Martin J. Chávez, Mayor

July 10, 1997

RE: REVISED DRAINAGE PLAN FOR TRACT A-2 ALBUQUERQUE RANCH ESTATES
(E22-D19) REVISION DATED 6/26/97

E-22

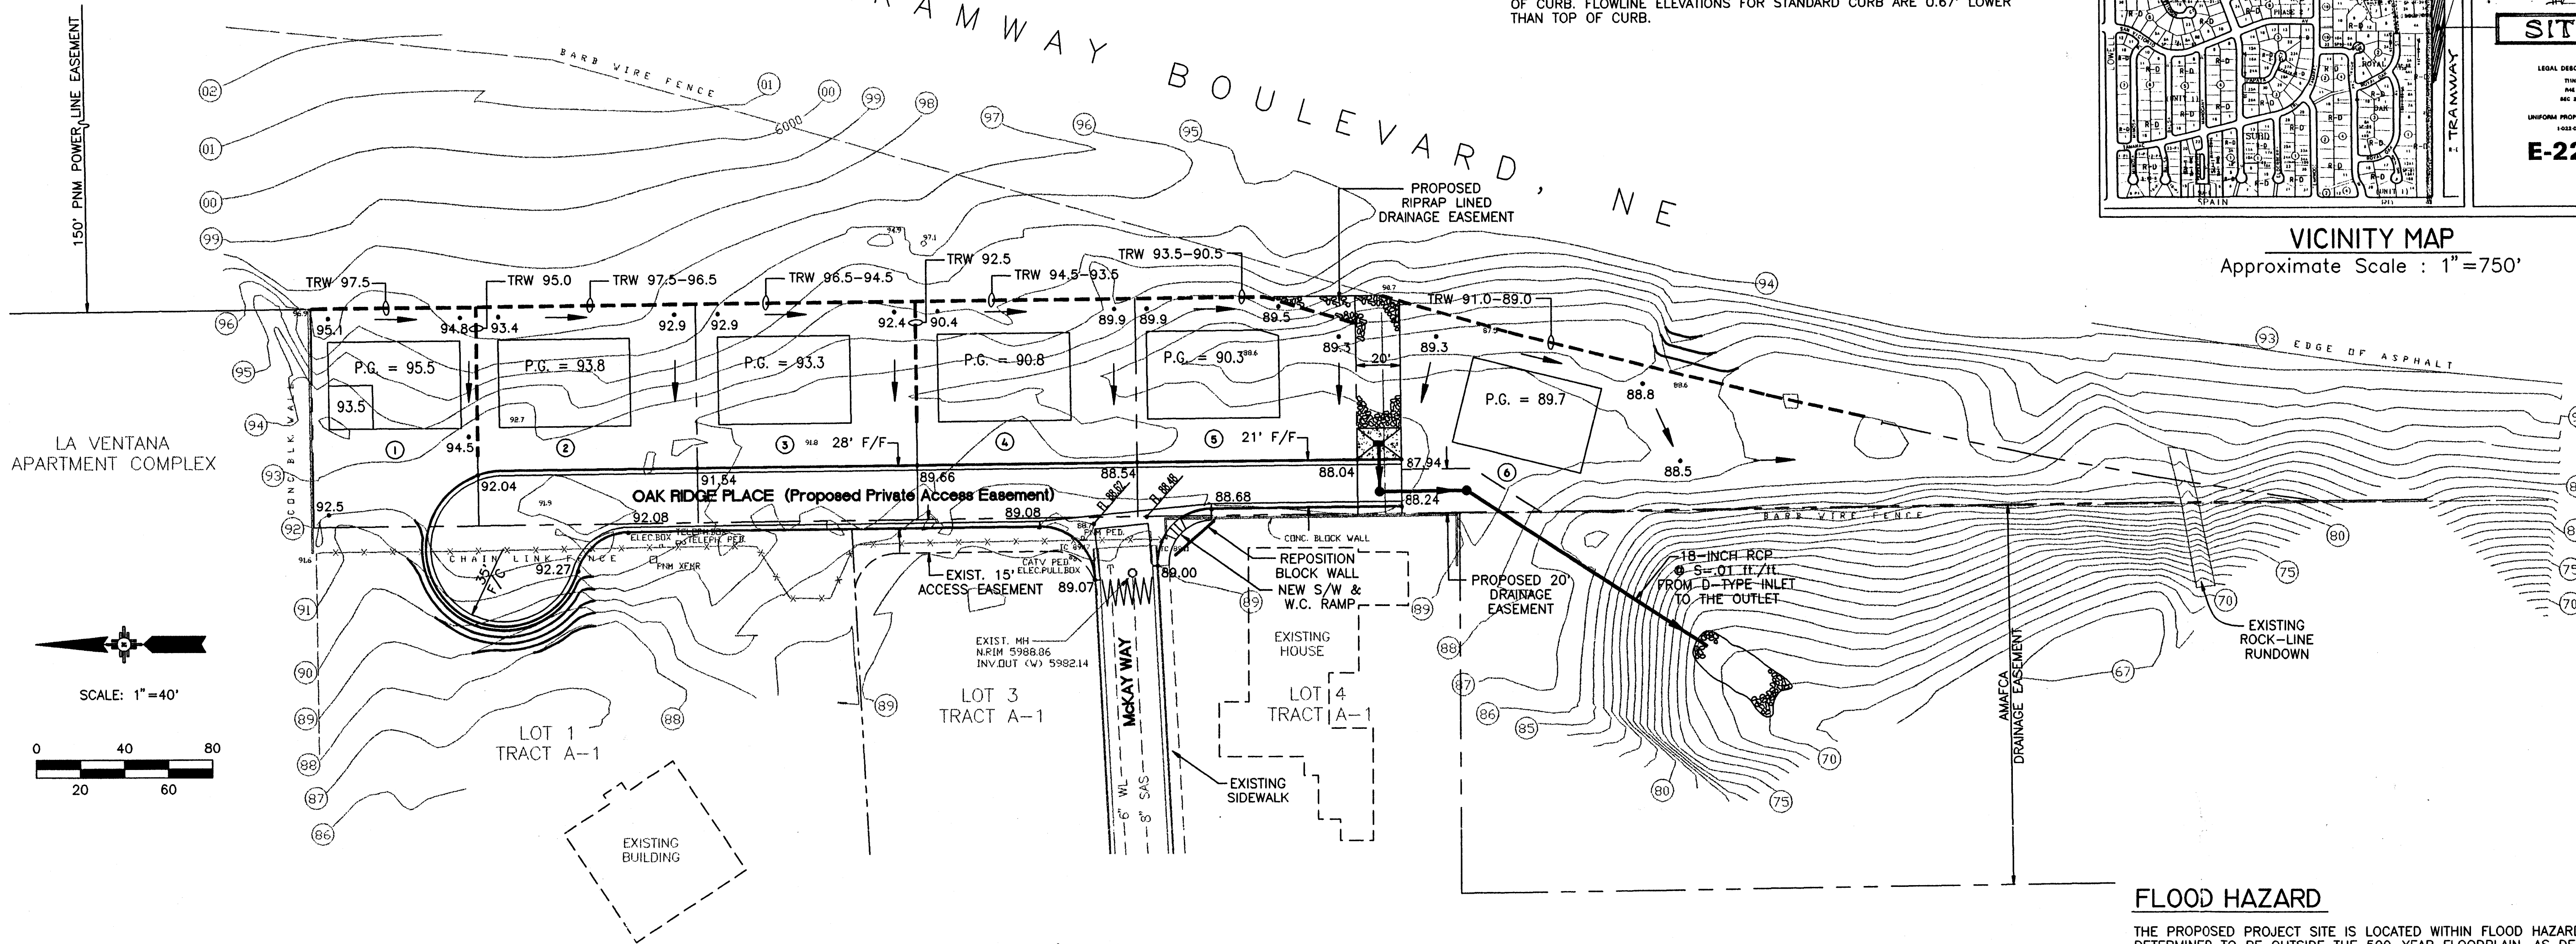
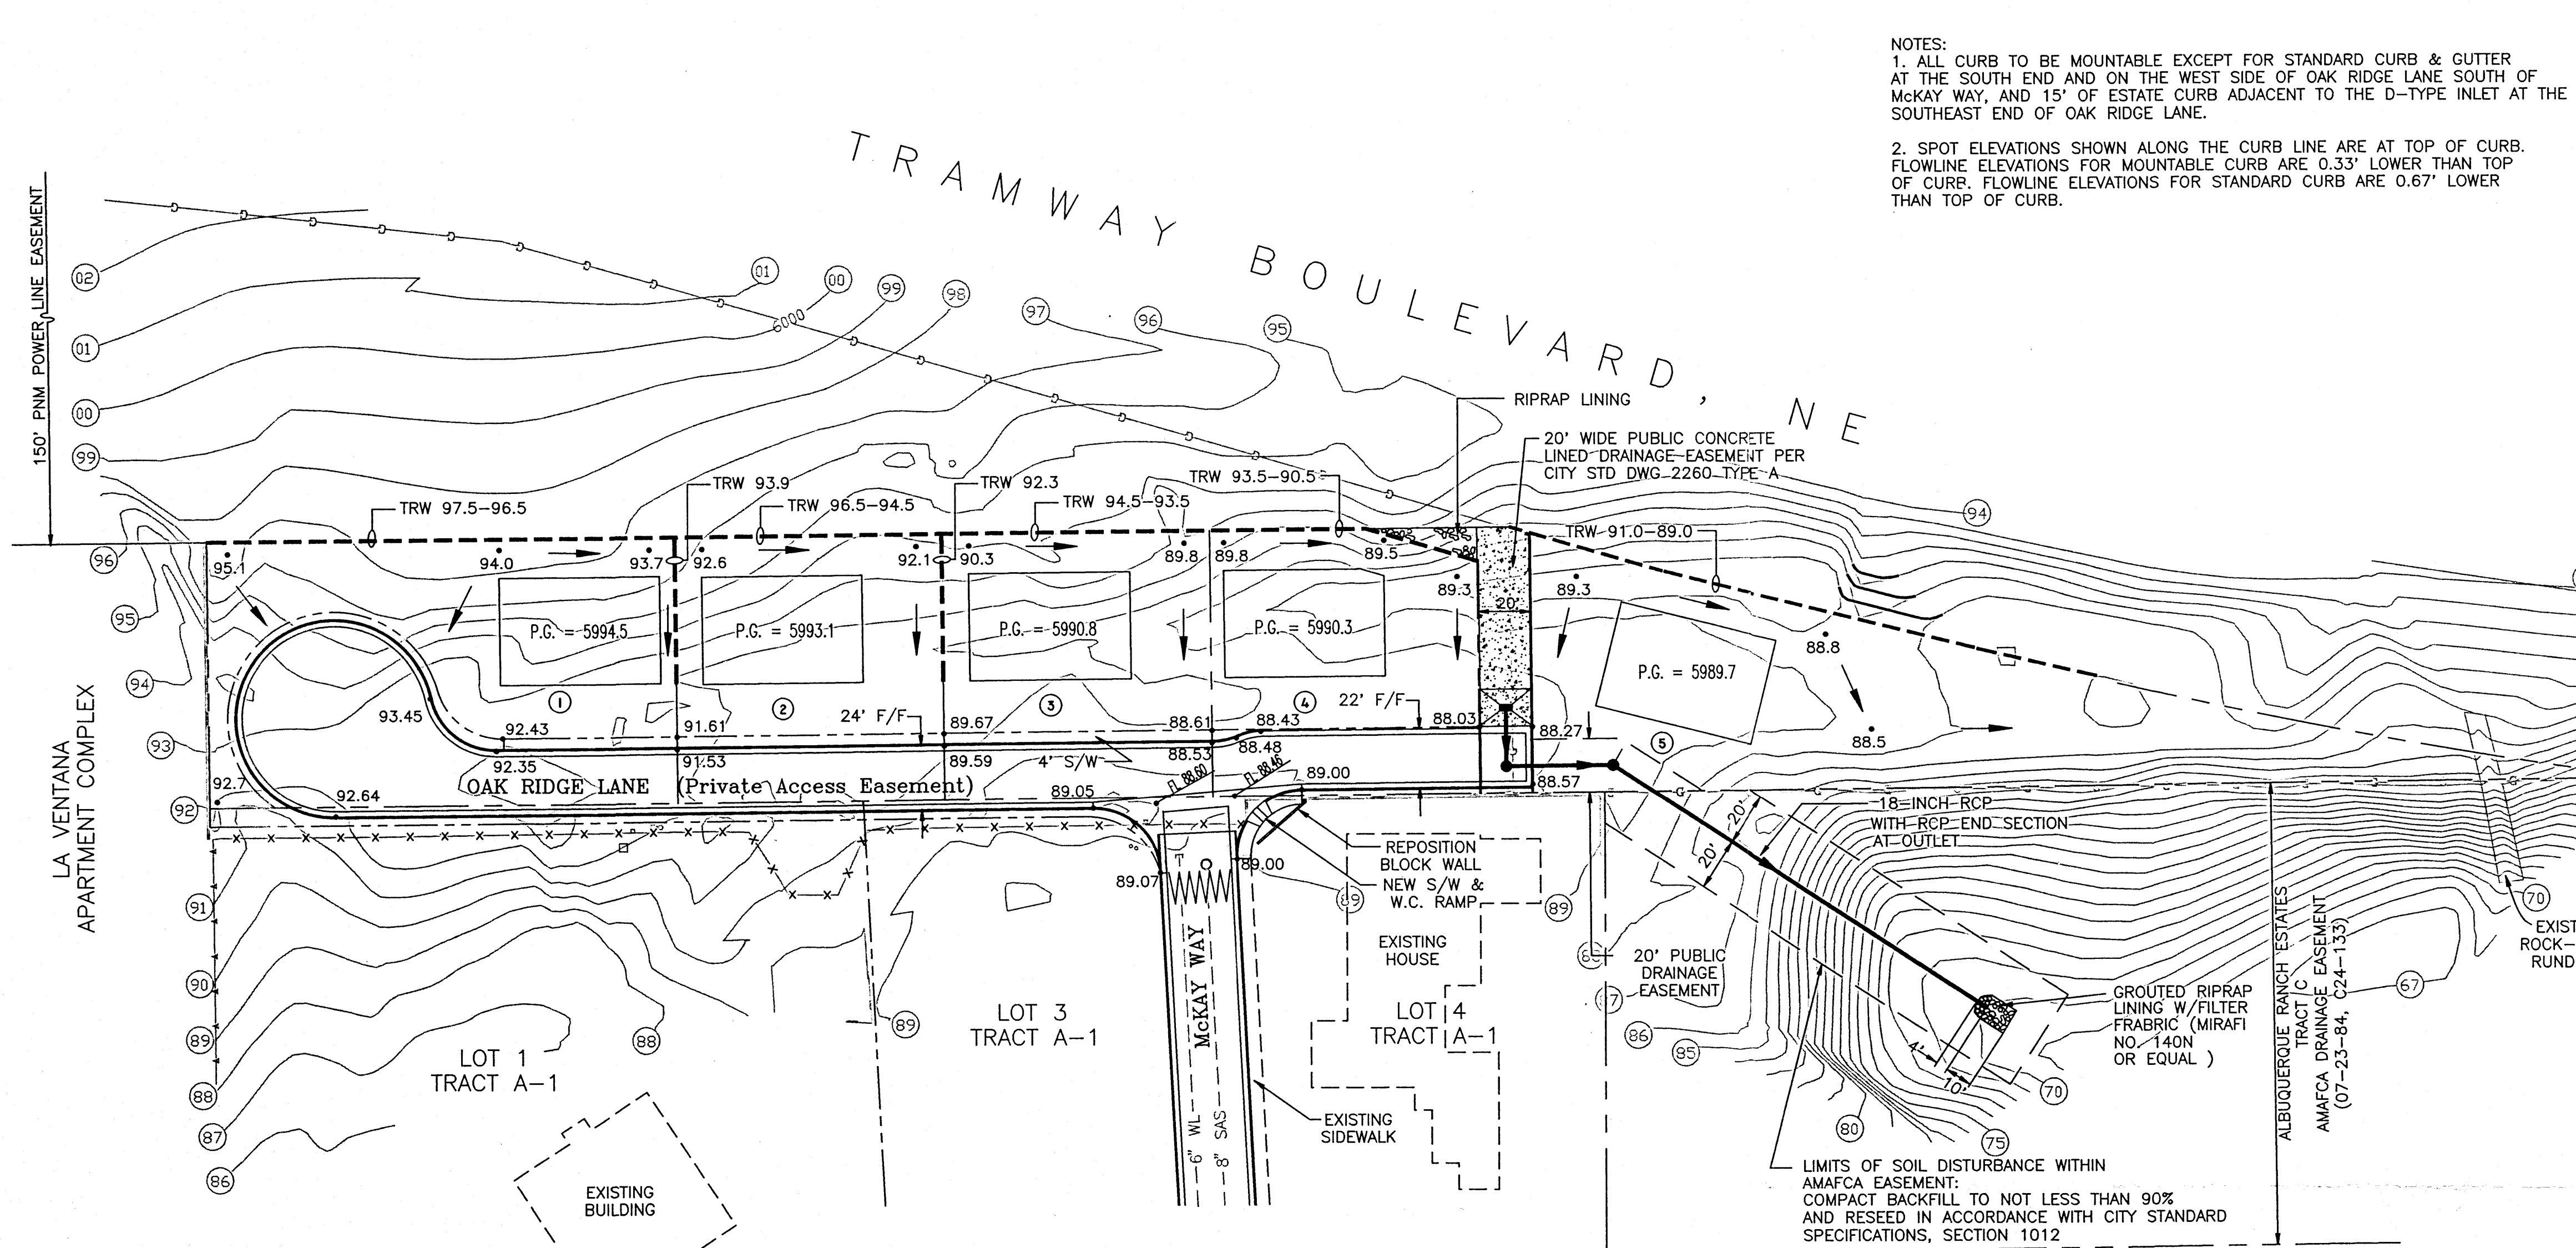
1. The proposed 20' drainage easement will be accepting public runoff from Tramway. Therefore the proposed easement must be designed to COA specs. It will need to be made part of the Work order and included in the infrastructure list.
2. AMAFCA approval must be obtained during the Work order process.
